File no: SSD 9368; MC-19-00004.

**Re: SSD9368 - Farmland Drive SCHOFIELDS – Alex Avenue Public School**

## ATTACHMENT A

SITEWORKS AND STORMWATER **MANAGEMENT PLAN - SHEET 03**

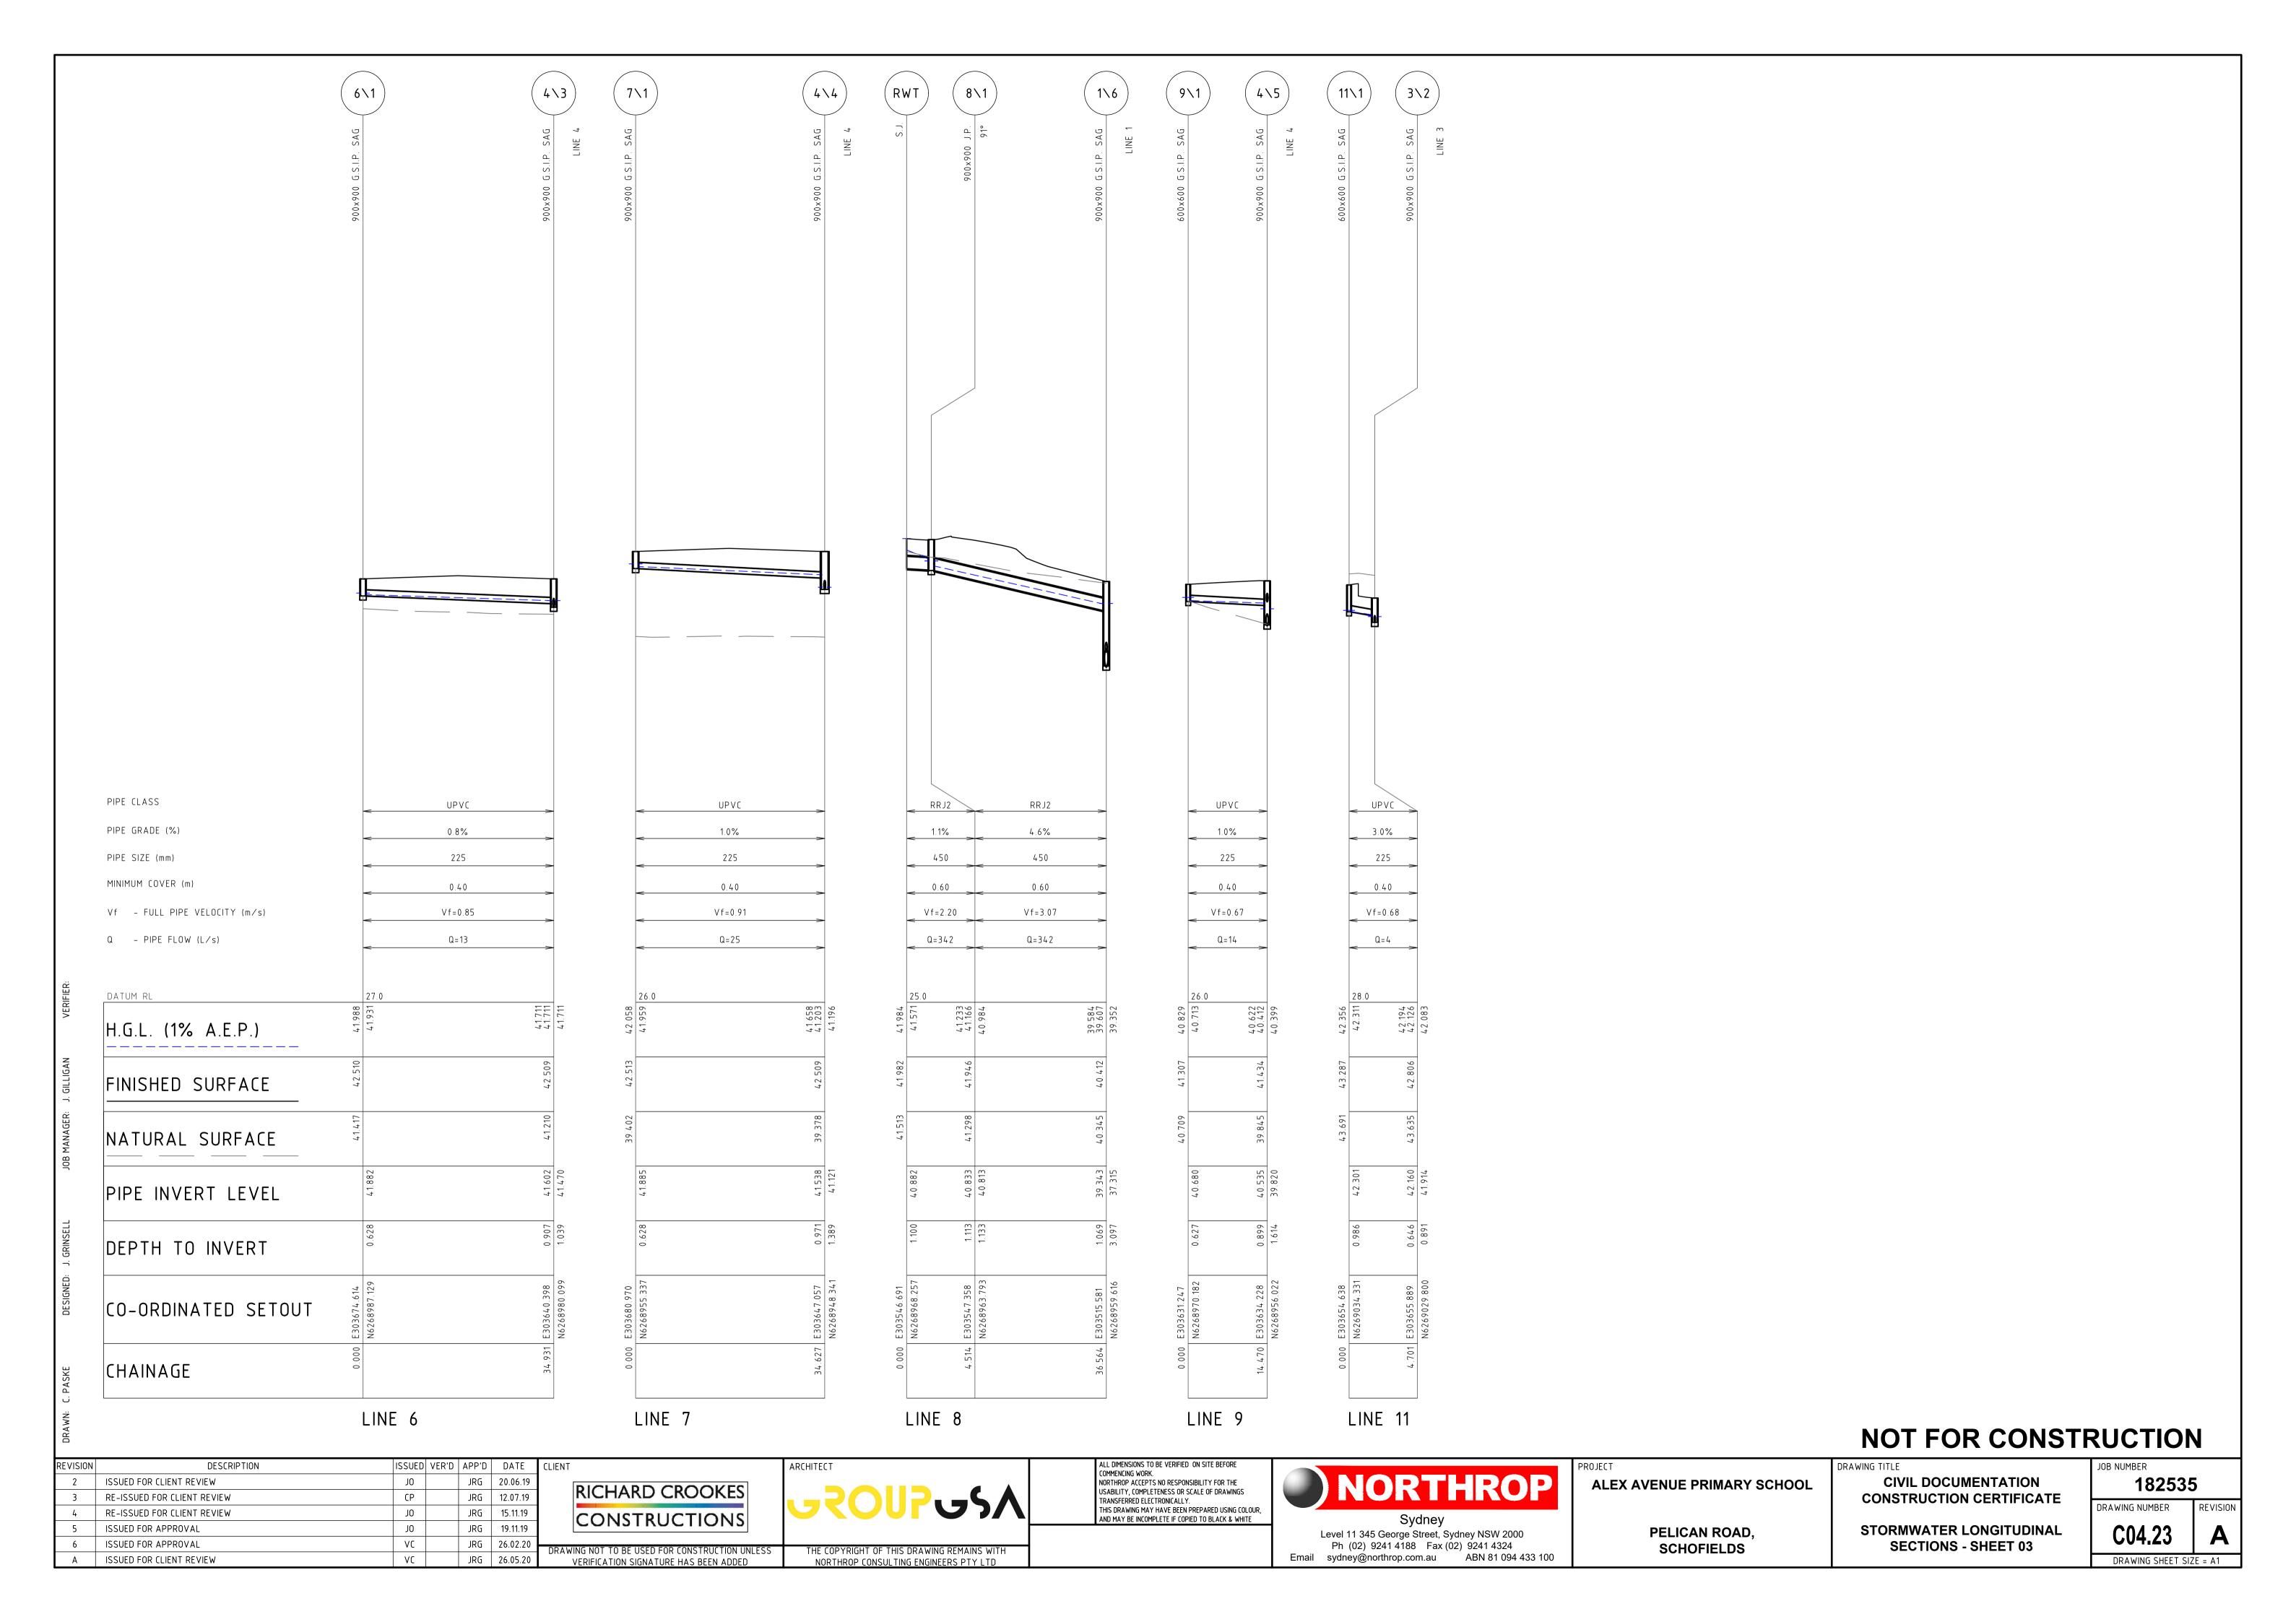
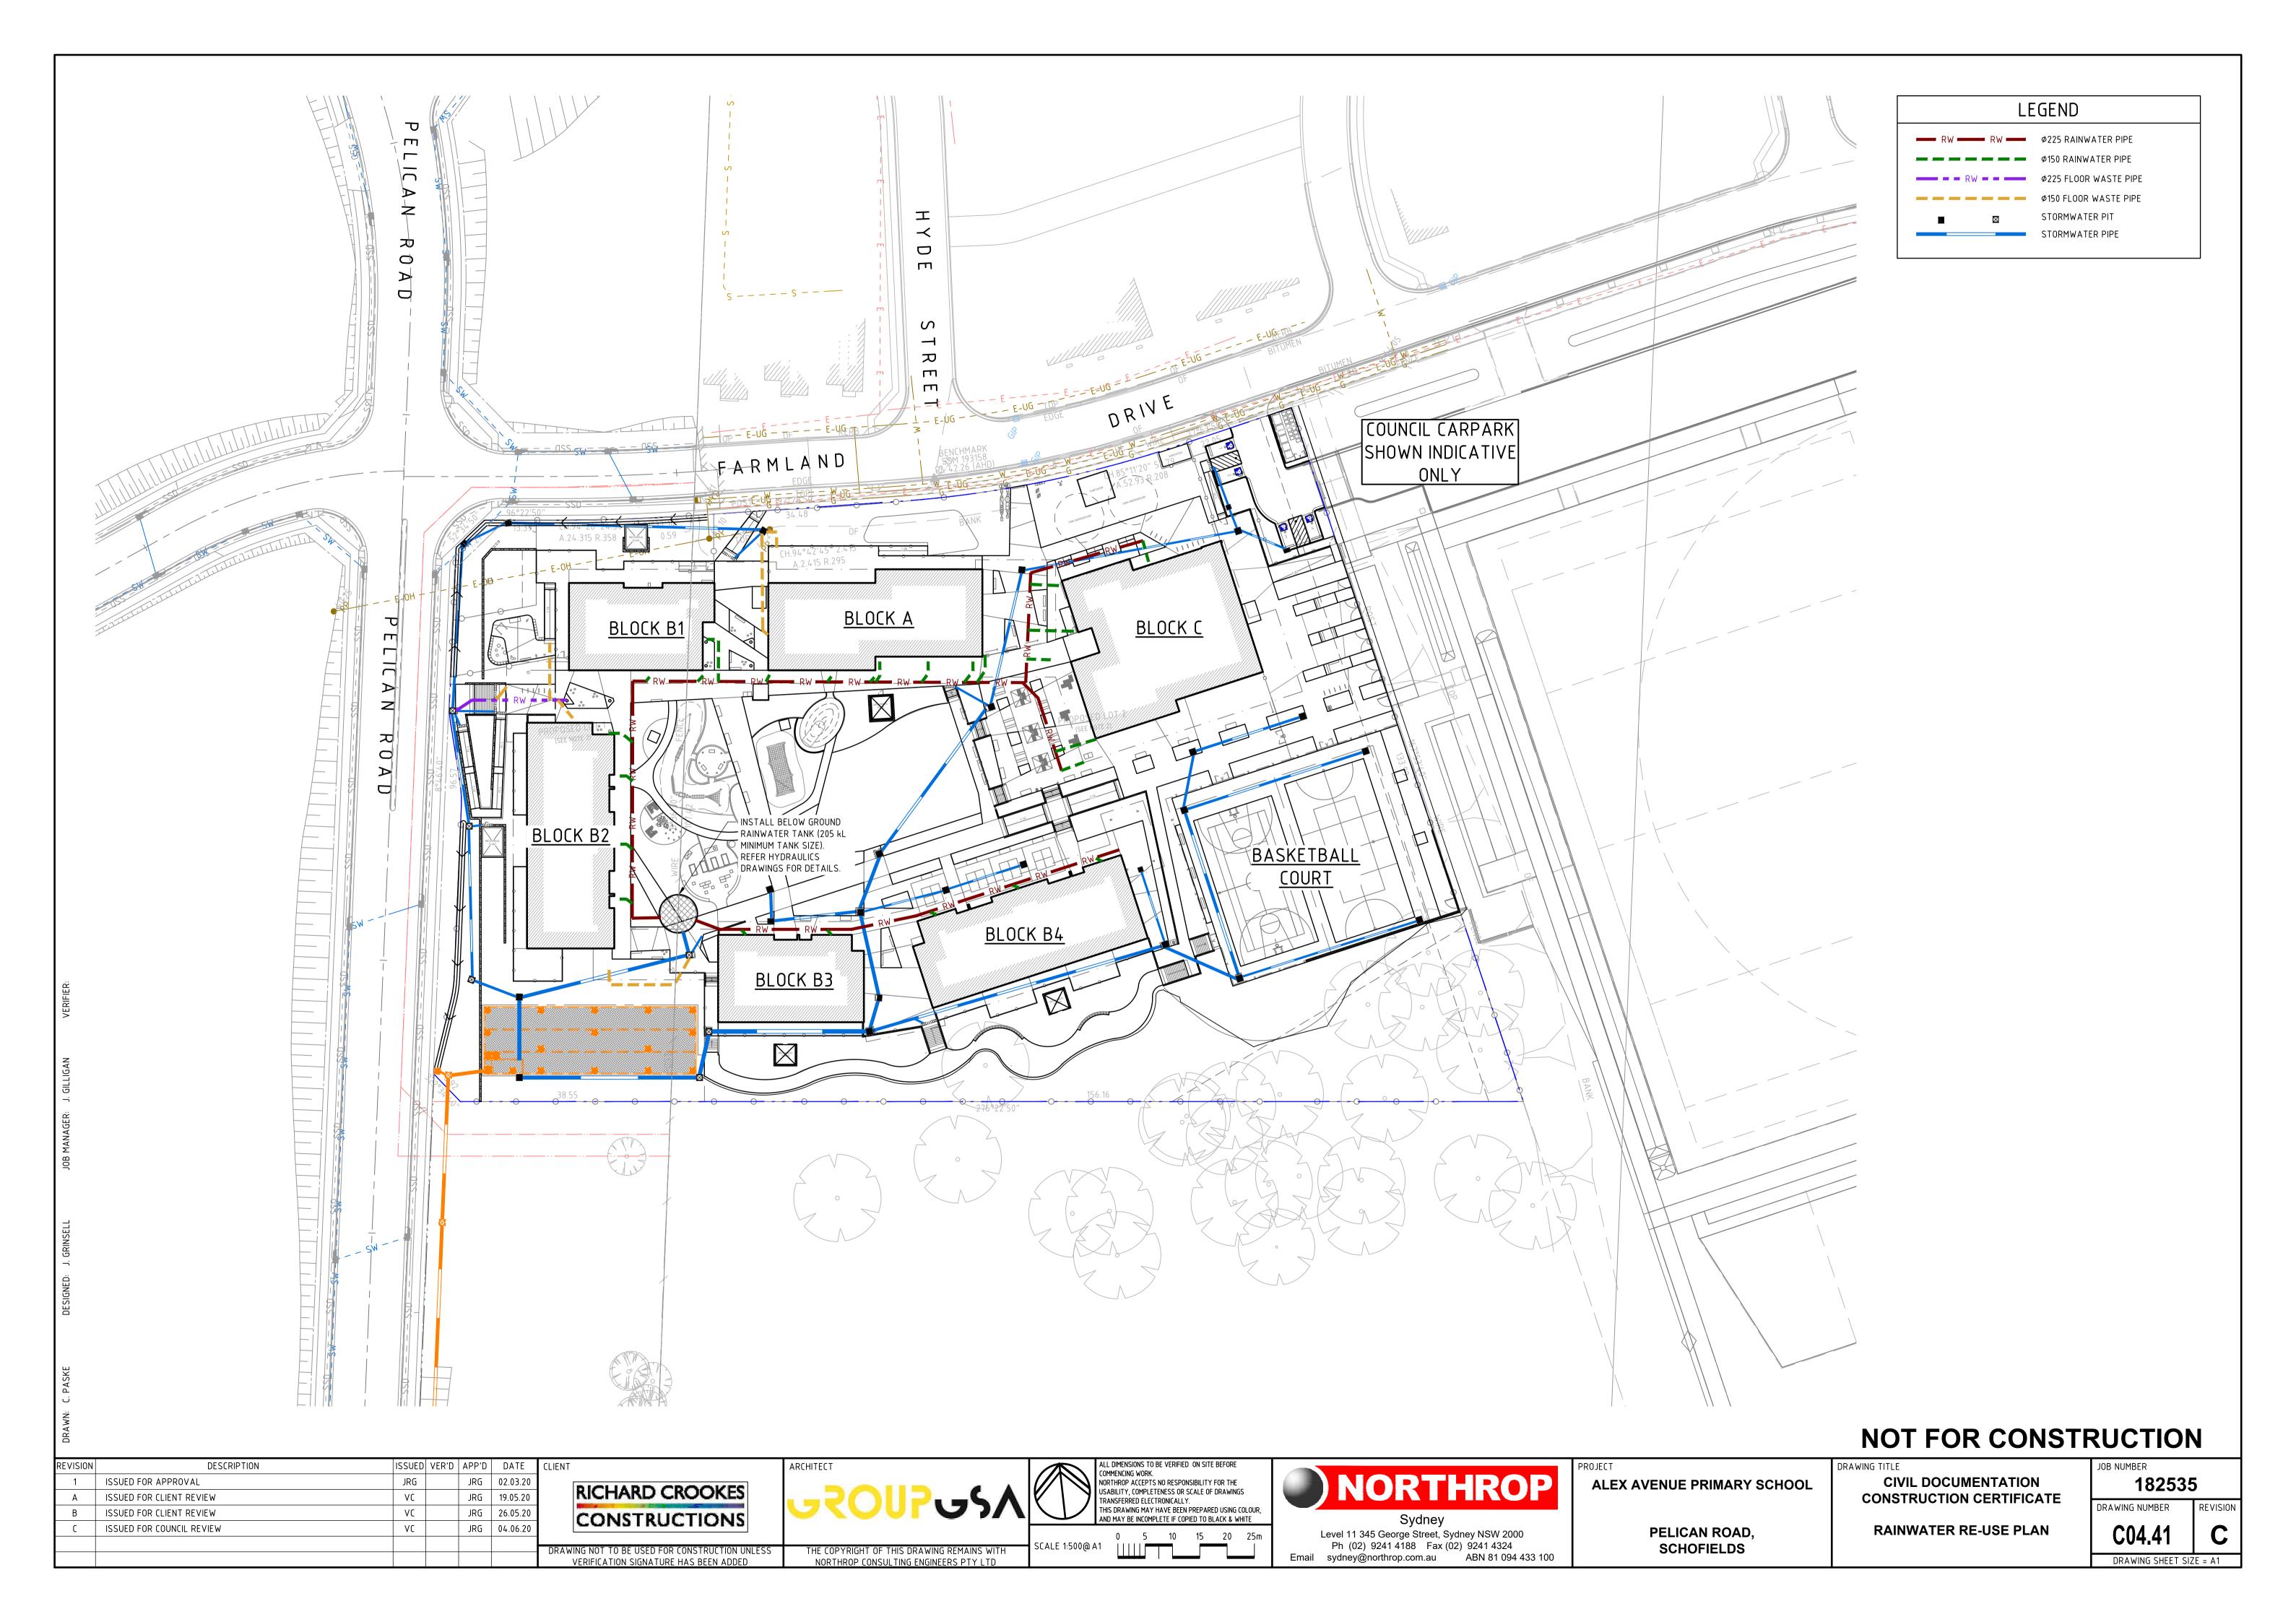
- a. The Media Filter, Transition and Drainage layer materials to comply with Plan No. A(BS)175M. Annotate these on the drawings.
  - b. Increase filter media depth to 500mm. Provide minimum 450mm transition layer and 200mm drainage layer.
  - c. Provide at least 2 cross-sections at right angles to each other.
  - d. Provide a cross-section through inlet pipe with levels.
  - e. Provide a cross-section through overflow pit with levels.
  - f. The bio-retention system shall be modelled as a submerged system as per Plan No. A(BS) 175M.
  - g. Provide inlet pits rather than a headwall to the bioretention. Refer to sheet 7 of the WSUD standard drawings.
16. The rip rap scour protection is shown in detailed drawings (Section A of C04.03) but not shown on the plan. Also Dwg. No. C04.03 does not exist.
  17. Provide an electronic version of MUSIC model.

22. Rename all pits on the long sections to match plan pit numbers i.e. 1/4 on plans should match the 1/4 on the long section, currently they do not.
23. Pit 1/9 is called for in the drainage long section yet not provided on the plan.

24. On all the long section, provide the HGL design storm in addition of the 100 and 2 year HGL.
25. Pit 4/2 in Dwg. No. DAC04.22 does not have adequate cover. The minimum cover is to be 100mm below a slab.

26. The rainwater tank incorrectly shows the roof drainage line connecting to both an outlet pit (4/1) and the rainwater tank. All roof drainage is to connect directly to the

rainwater tank with the rainwater tank having a separate overflow drainage line to the stormwater system.
